Planning and Urban Development Department

Subject: IOZ Design Review – 22 Bramhall (Maine Medical)
Written by: Caitlin Cameron, Urban Designer
Date of Review: Thursday, October 4, 2018

This memo summarizes the applicable design guidelines and staff review for the project at 22 Bramhall Street – Congress Street Medical Building. This project is reviewed according to the adopted IOZ IDP and Regulatory Framework standards.

Fig.5.19 Computer-generated shadow study / Existing conditions on December 21, noon

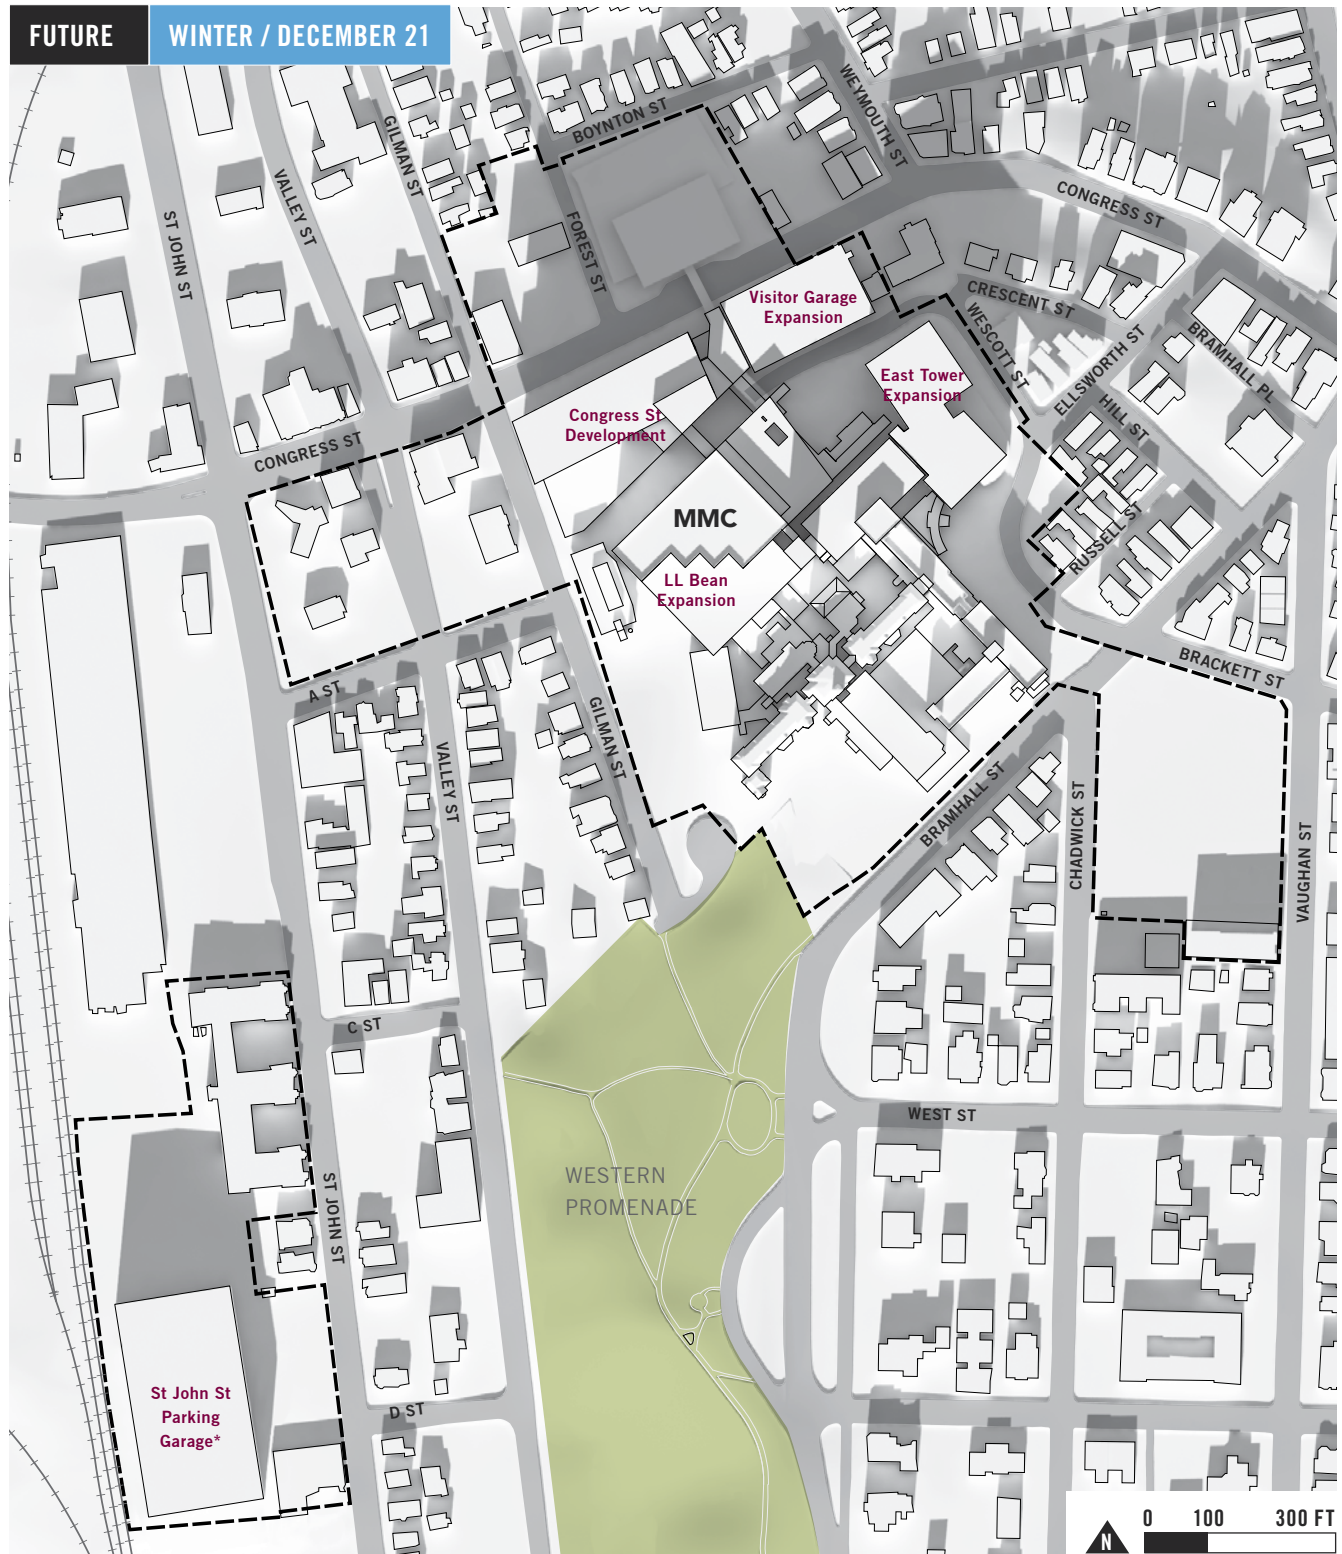
Minimizing Shadow Impacts - Shadow impacts were evaluated as part of the IDP process. The proposed project is shorter but also closer to the street than the existing garage. The impacts as shown in the IDP figures 5.17 through 5.20 show that **additional shadow is created on the street year round and also for one residential building in the winter by this building.**

1 ENLARGED PLAN - C2 GREEN ROOF  
1/8" = 1'-0"

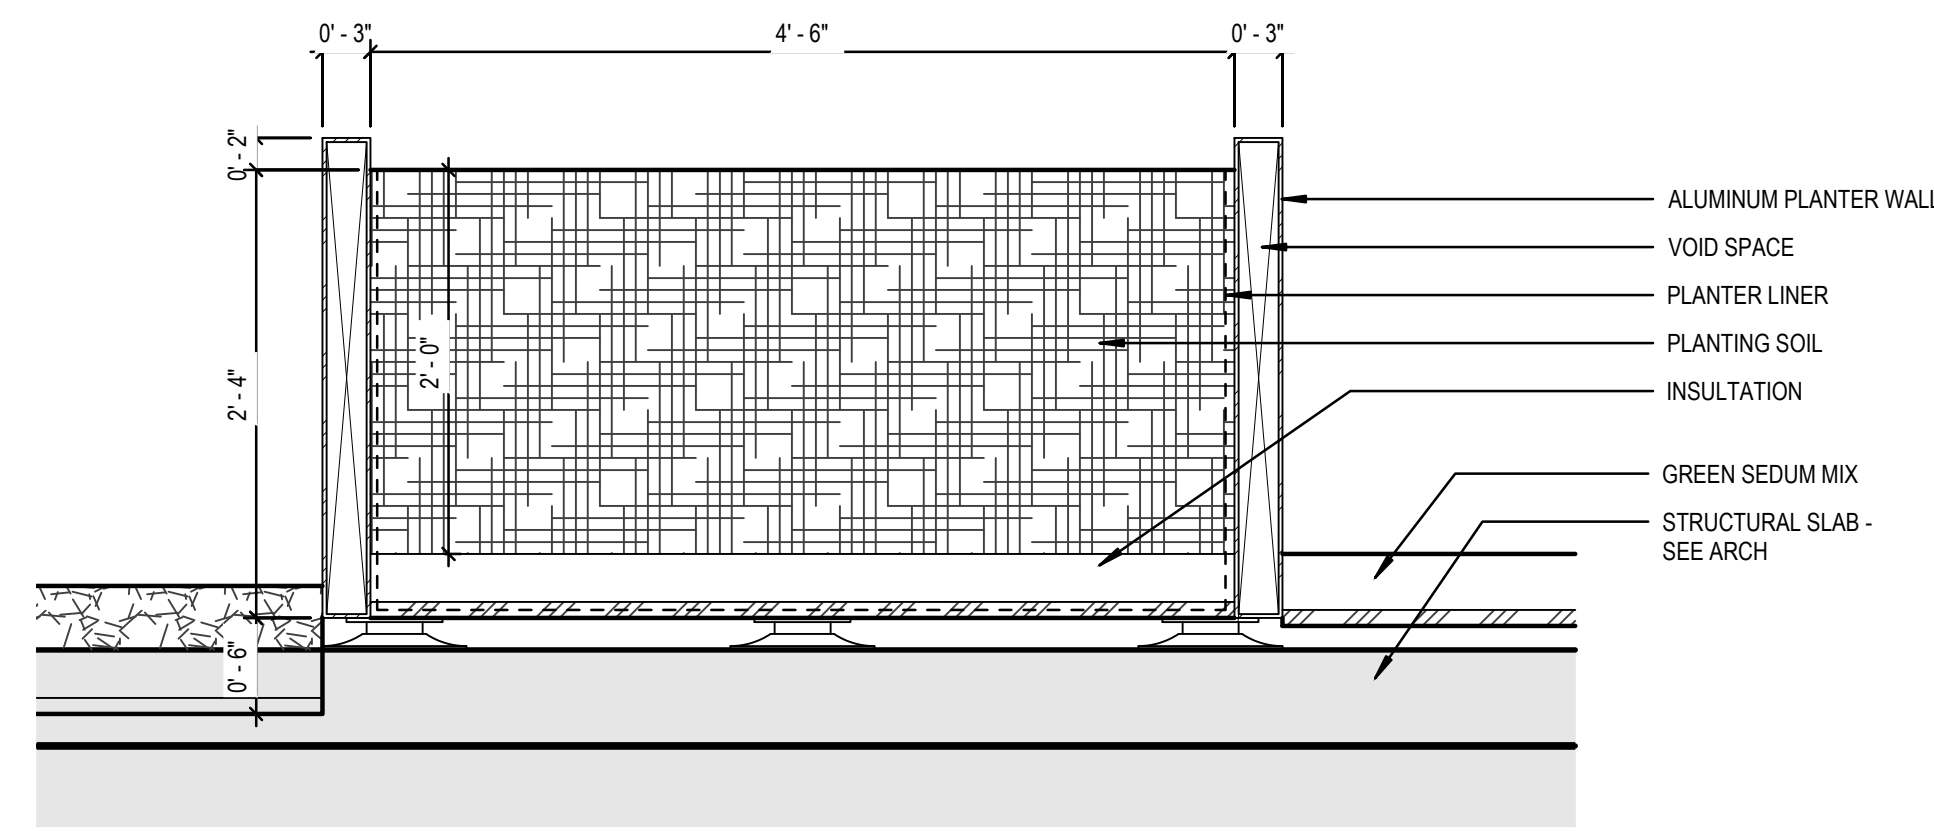
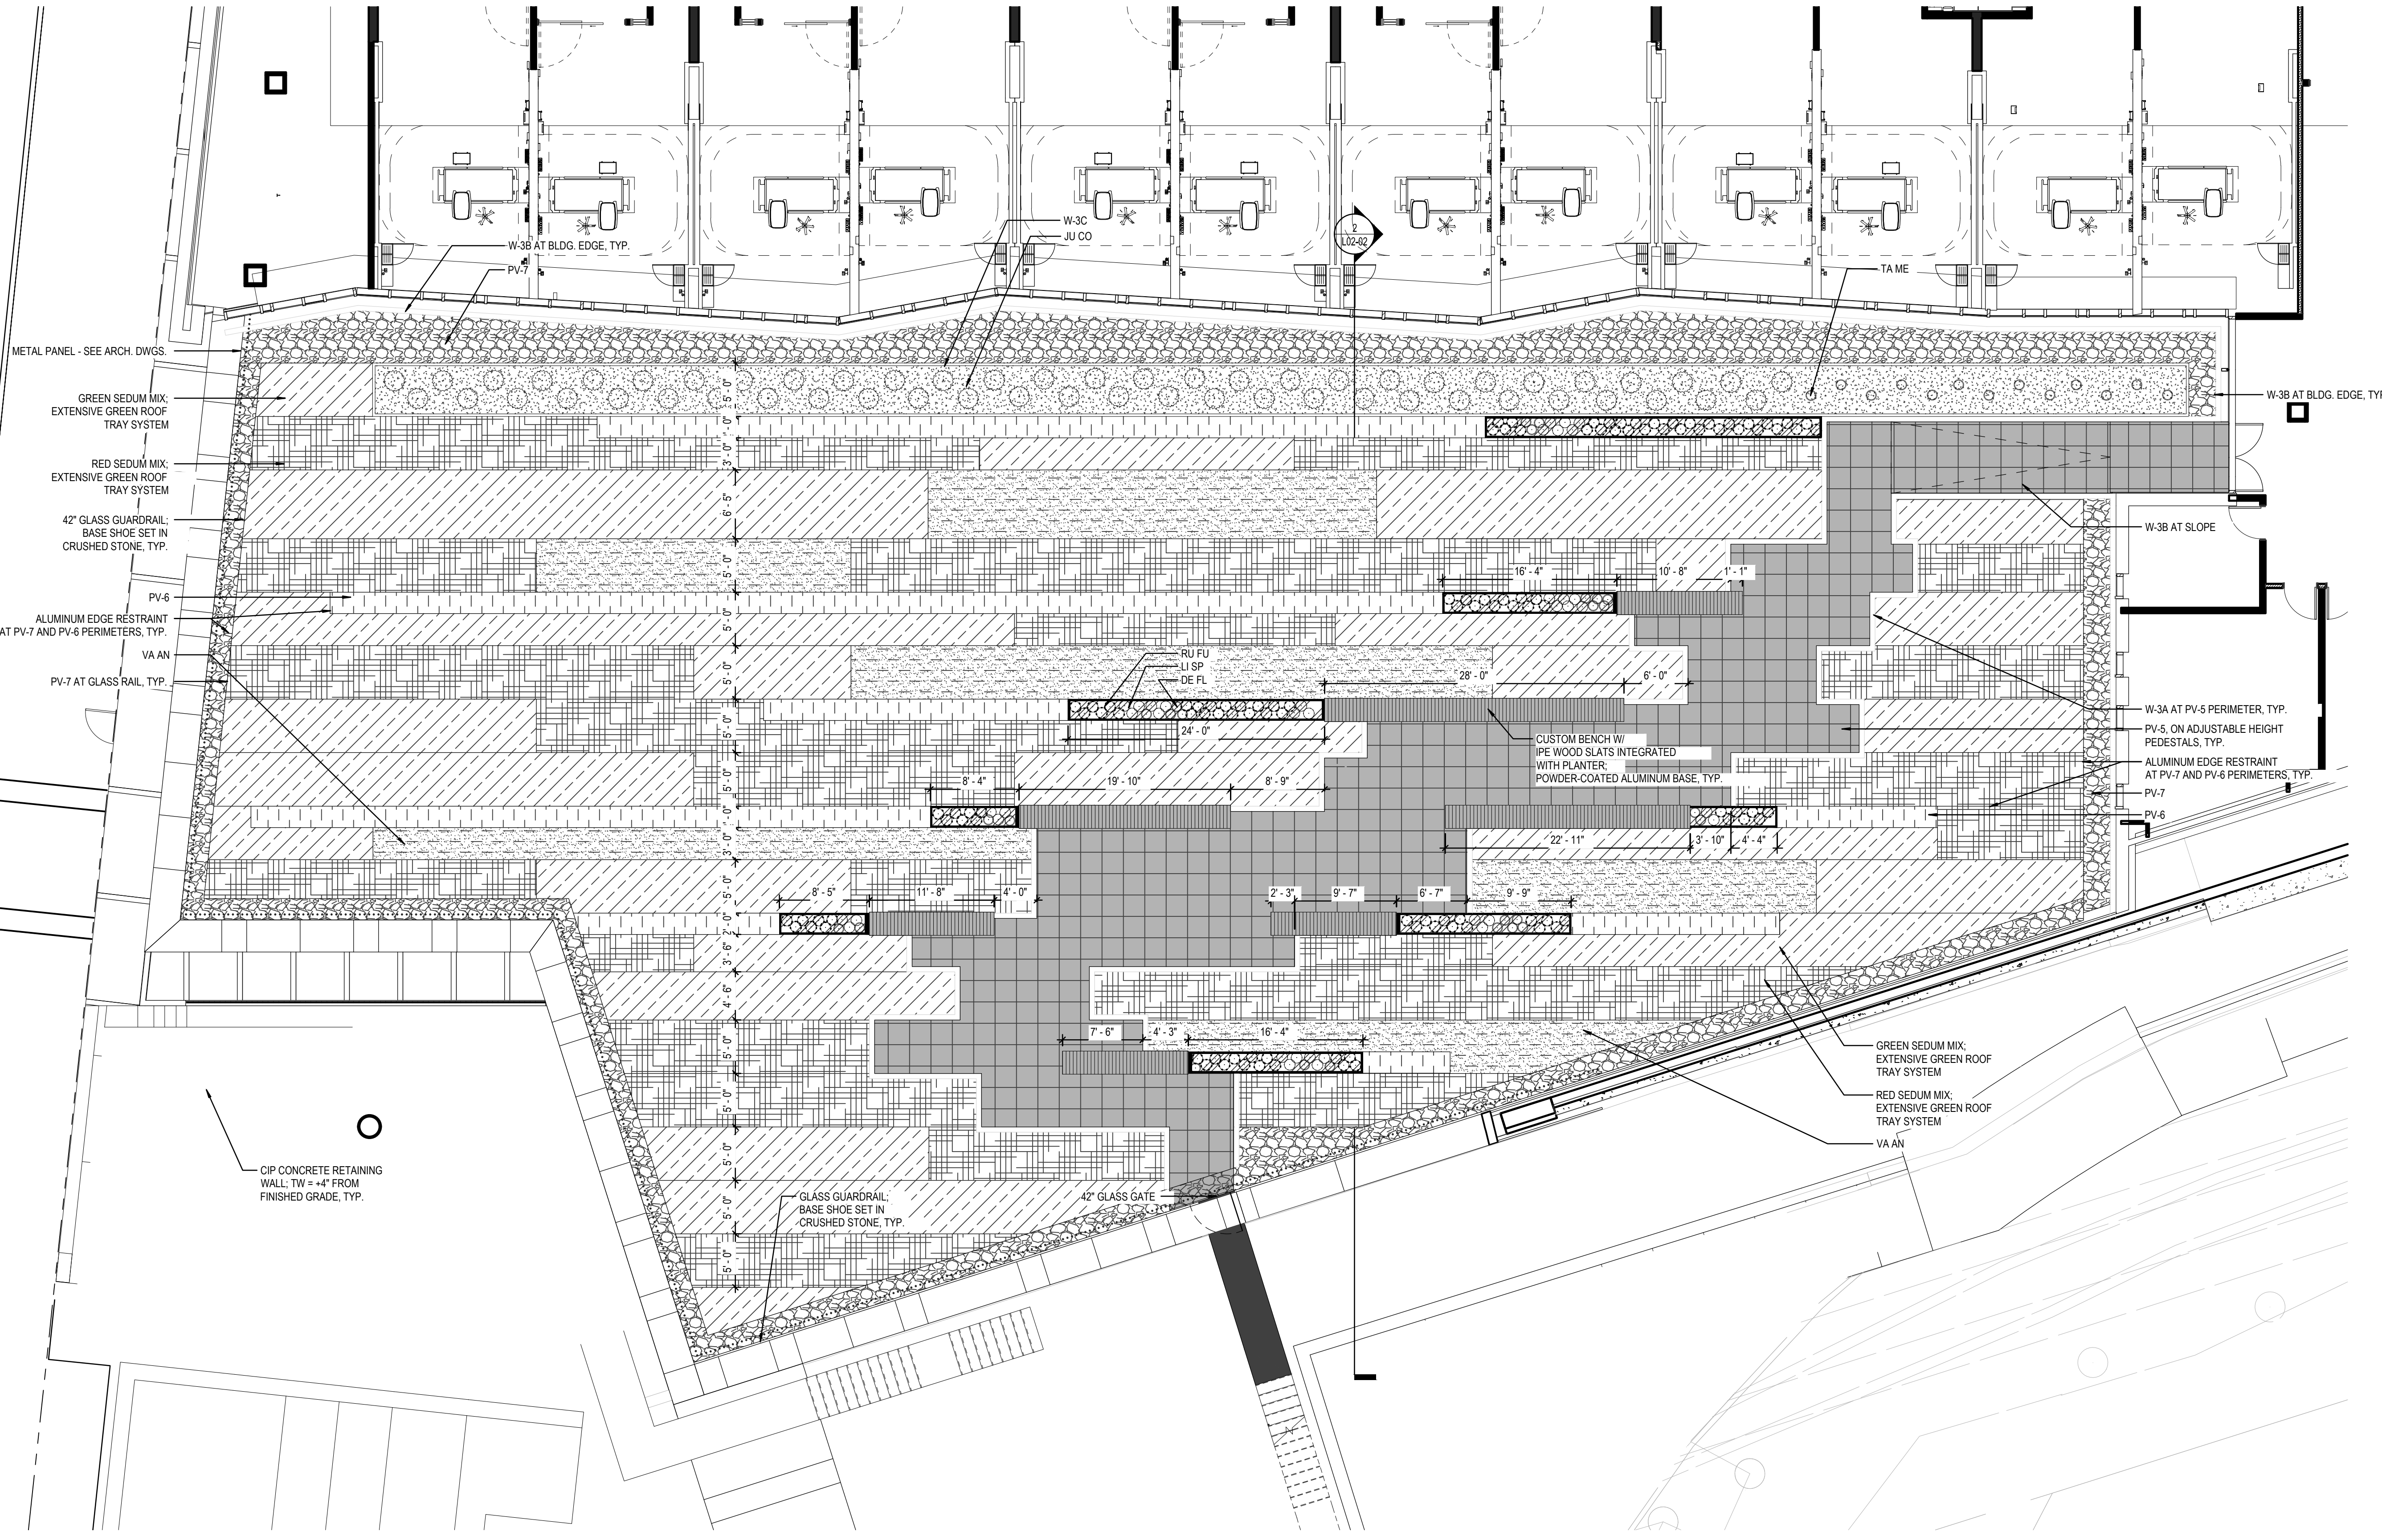
Some rooftop mechanicals are housed in an area setback to the interior of the lot and are adequately integrated into the building forms. **However, there are some small rooftop appurtenances are not included in the rendered images** – there will be some stacks that poke

through this roof. From the ground level, these will not be visible. But it is important to consider that the roof as perceived from above will not be as flat and clean as shown. There is also a green roof section of the building, but again, its height and position mean it will not be viewed from many places. The building is low and difficult to perceive from the long views – a future phase addition is also intended above this building.

Preliminary Sign Location Plan

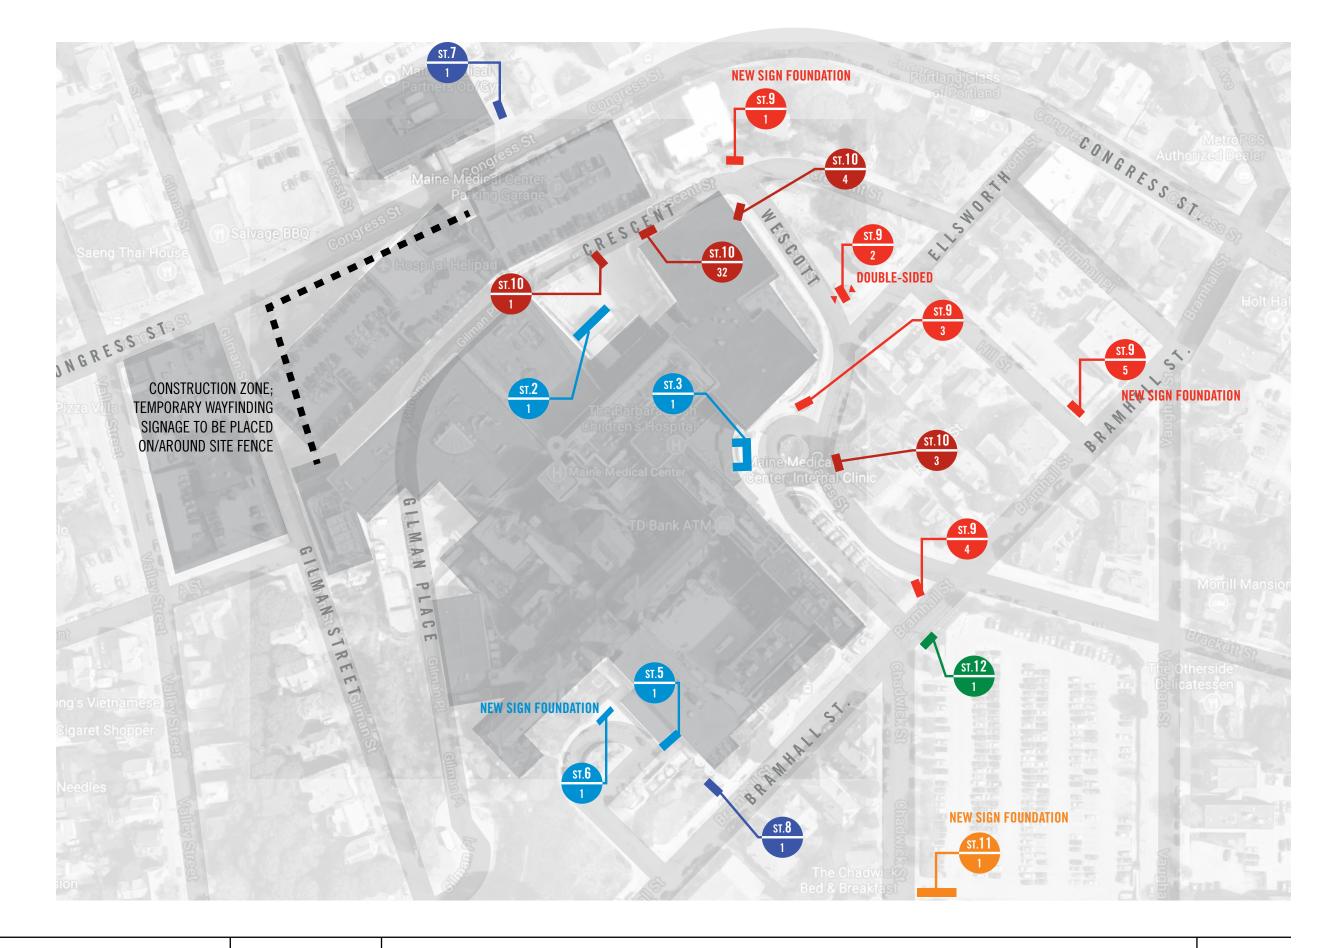
- Campus-wide Signage Plan: The draft campus-wide signage plan is included in this submission. Staff had the following comments:
 - o Signs will not be permitted on properties not owned by MMC – remove the proposed sign on City property at Bramhall Square.

- o There are concerns about sight line obstructions on several of the signs, including 1.a, CS.2, and EG.1a. Please provide sight line analysis.
 - o There are concerns about the height of some monument signs (ST4.a and ST6.a) shown at 11’0” tall next to sidewalk locations – sight lines and pedestrian scale are factors here.

- Individual Sign Design:
 - o South parking lot signage: Two signs facing the same street are not appropriate, not necessary, and create too much visual clutter – eliminate one of the signs (5.b). Reduce the overall size.
